Bower Hill, Oxspring

Highways Technical Note

Response to Highways Comments from BMBC

Planning Application Reference: 2025/0775

PROPOSED SITE PLAN

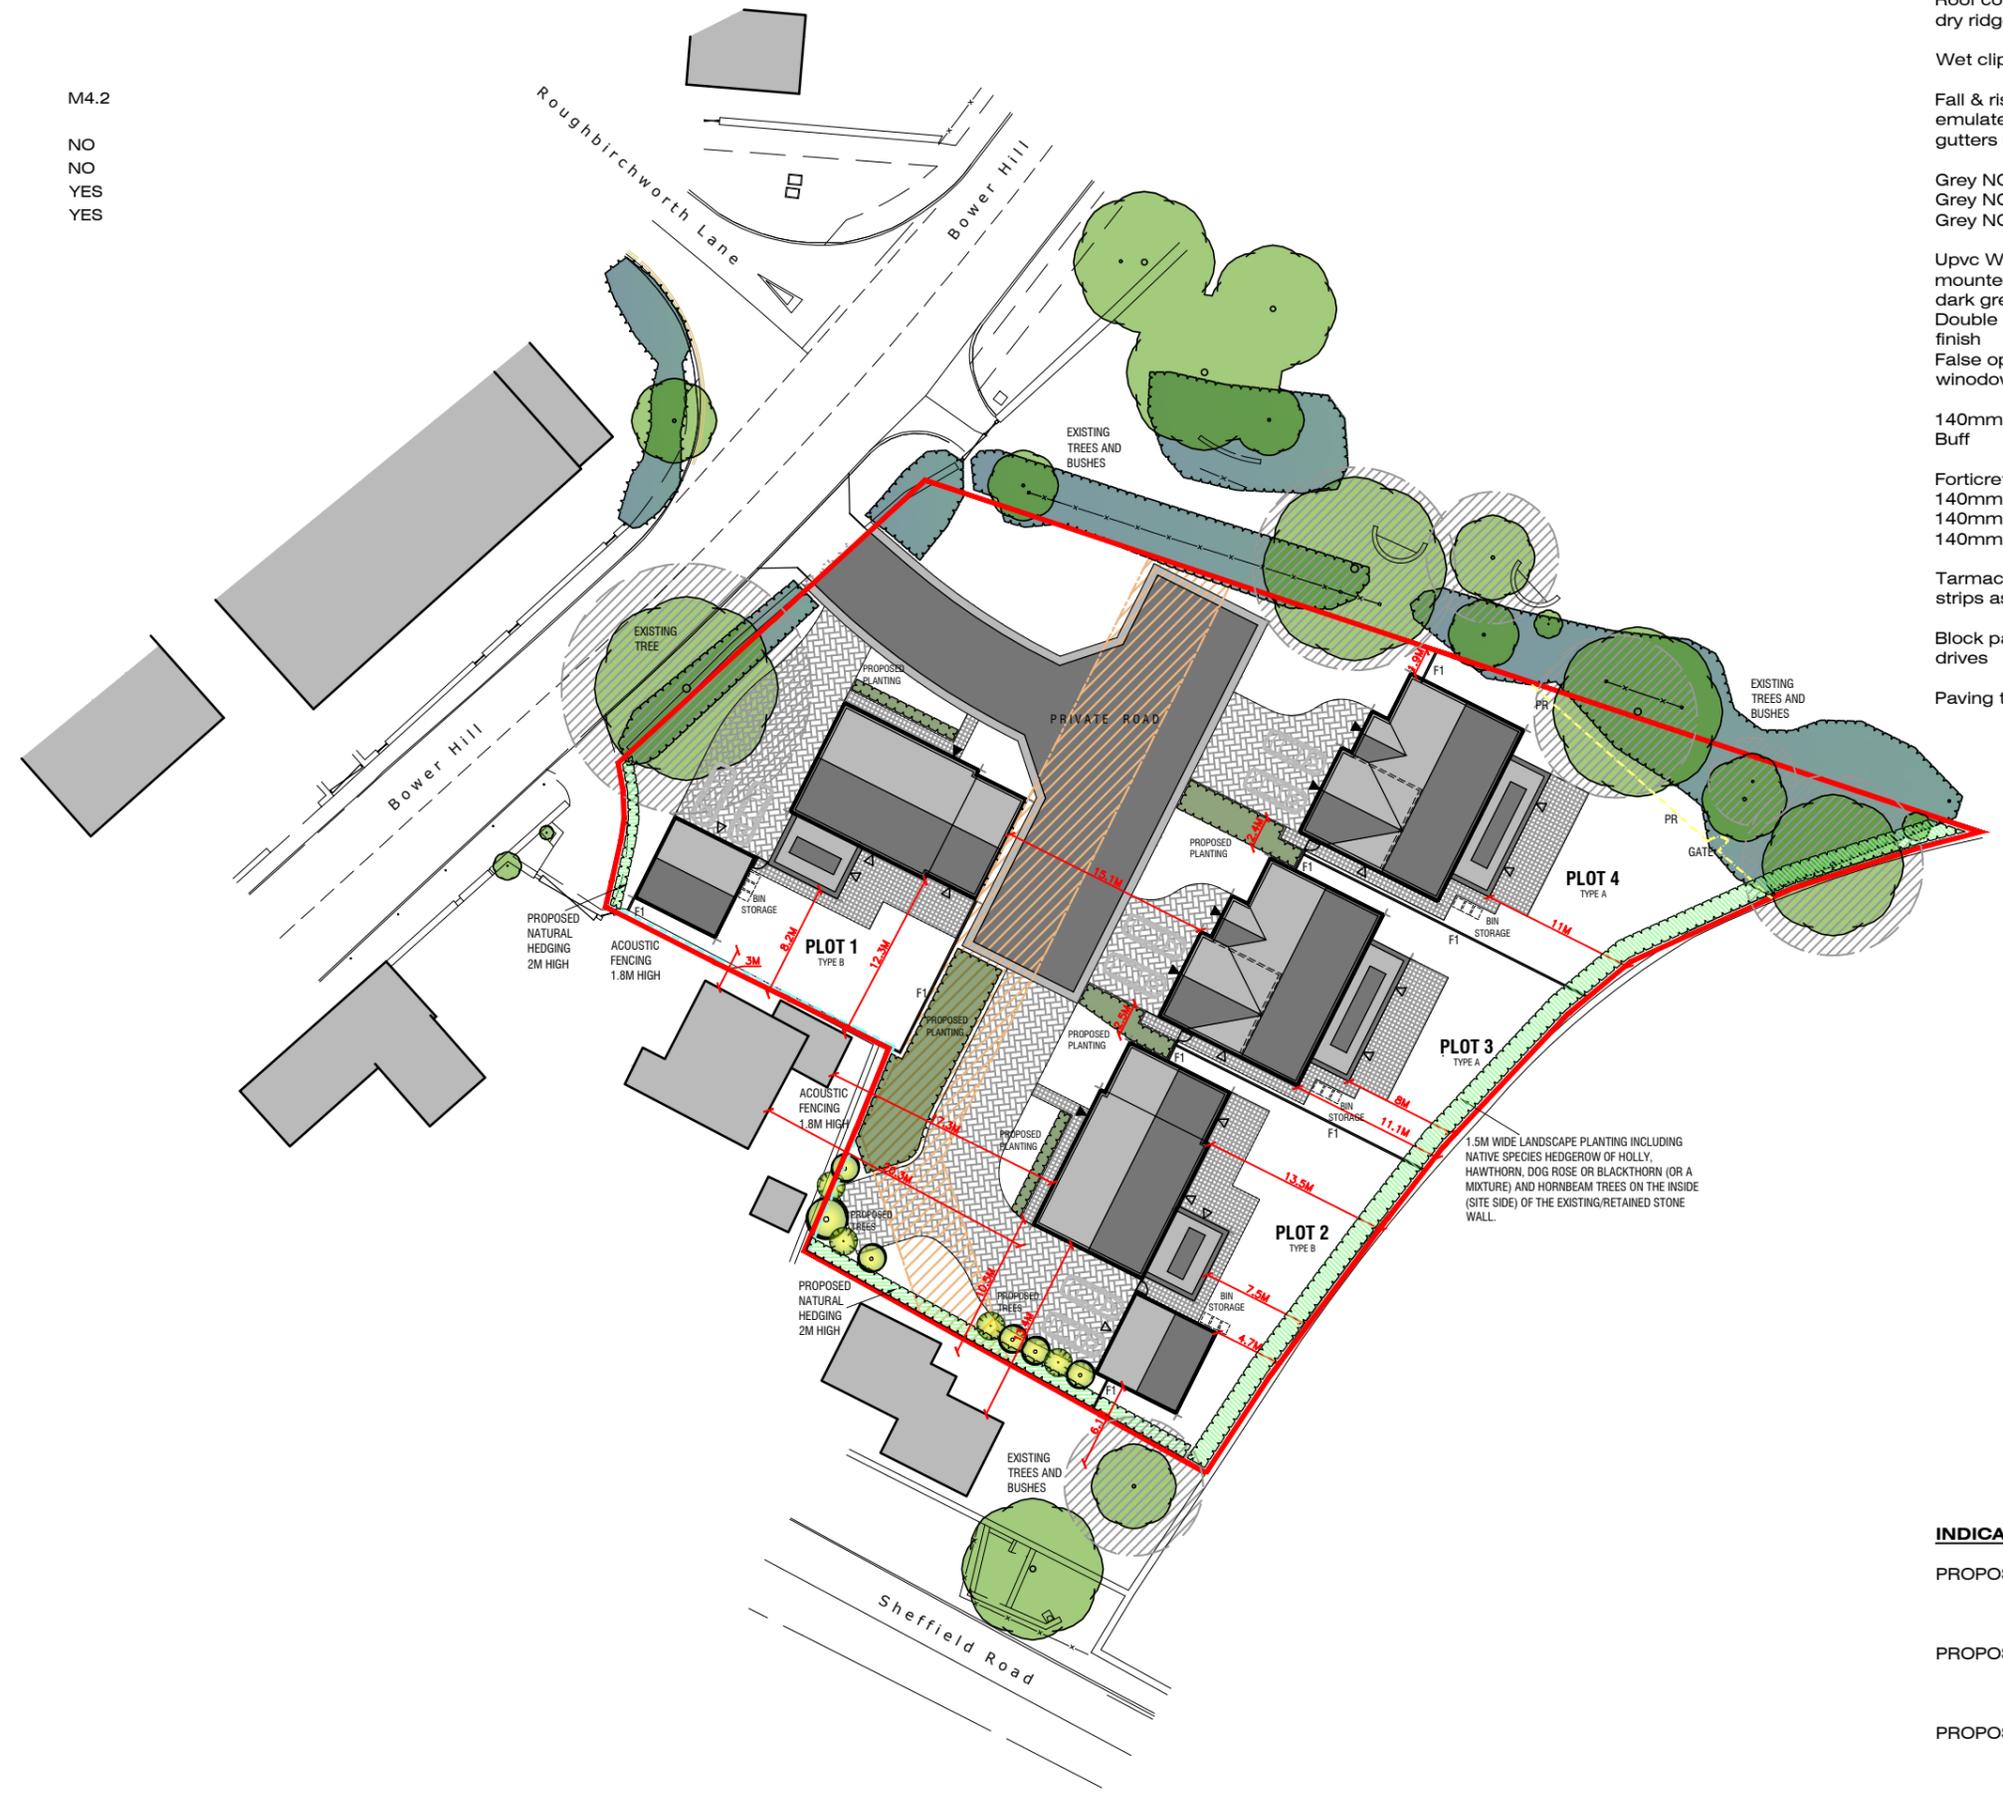
Whilst the scale of development is relatively modest, the proposed access arrangement raises significant highway safety concerns. The access is positioned in very close proximity to the junction with Roughbirchworth Lane and directly opposite its mouth, resulting in an absence of junction spacing and potential for conflict between turning movements. In addition, the proposed access lies adjacent to an existing field access and the vehicular access serving the nearby public house, further compounding the potential for conflicting vehicle movements and obstructed visibility at the site frontage.

The surrounding highway environment is constrained, with narrow carriageways and an absence of continuous footway provision along Bower Hill. The available pedestrian routes are substandard in both width and continuity, and there is a lack of convenient access to public transport facilities or key local amenities. As such, the site offers poor opportunities for sustainable travel, and it is likely that most trips, including those for employment, education and to access local amenities, would be undertaken by private car. This is contrary to the aims of the National Planning Policy Framework to promote sustainable modes of travel and reduce the reliance on the private motor vehicle.

The centreline to centreline measurement is approximately 10m which is considered acceptable given Roughbirchworth Lane forms a minor road and the proposed road forms a private drive.

Clear visibility splays are available from the proposed private drive onto Bower Hill in line with the posted speed limit, as per the submitted HSS.

Taking into account the Officers comments, the proposed access design has been revised to include a new section of footway to the right (north east) of the proposed private drive. This ties into the existing footway on Bower Hill which provides access to the Riverside Picnic Area and the Trans Pennine Trail. Given the locational constraints of the existing telegraph pole as per the recent topographical survey, the proposed footway measures 1.7m in width with a 0.5m construction offset provided from the pole itself. The grassed verge will be retained directly north of the proposed footway as per the surrounding footways. The preliminary drawing is attached at [Appendix B](#).
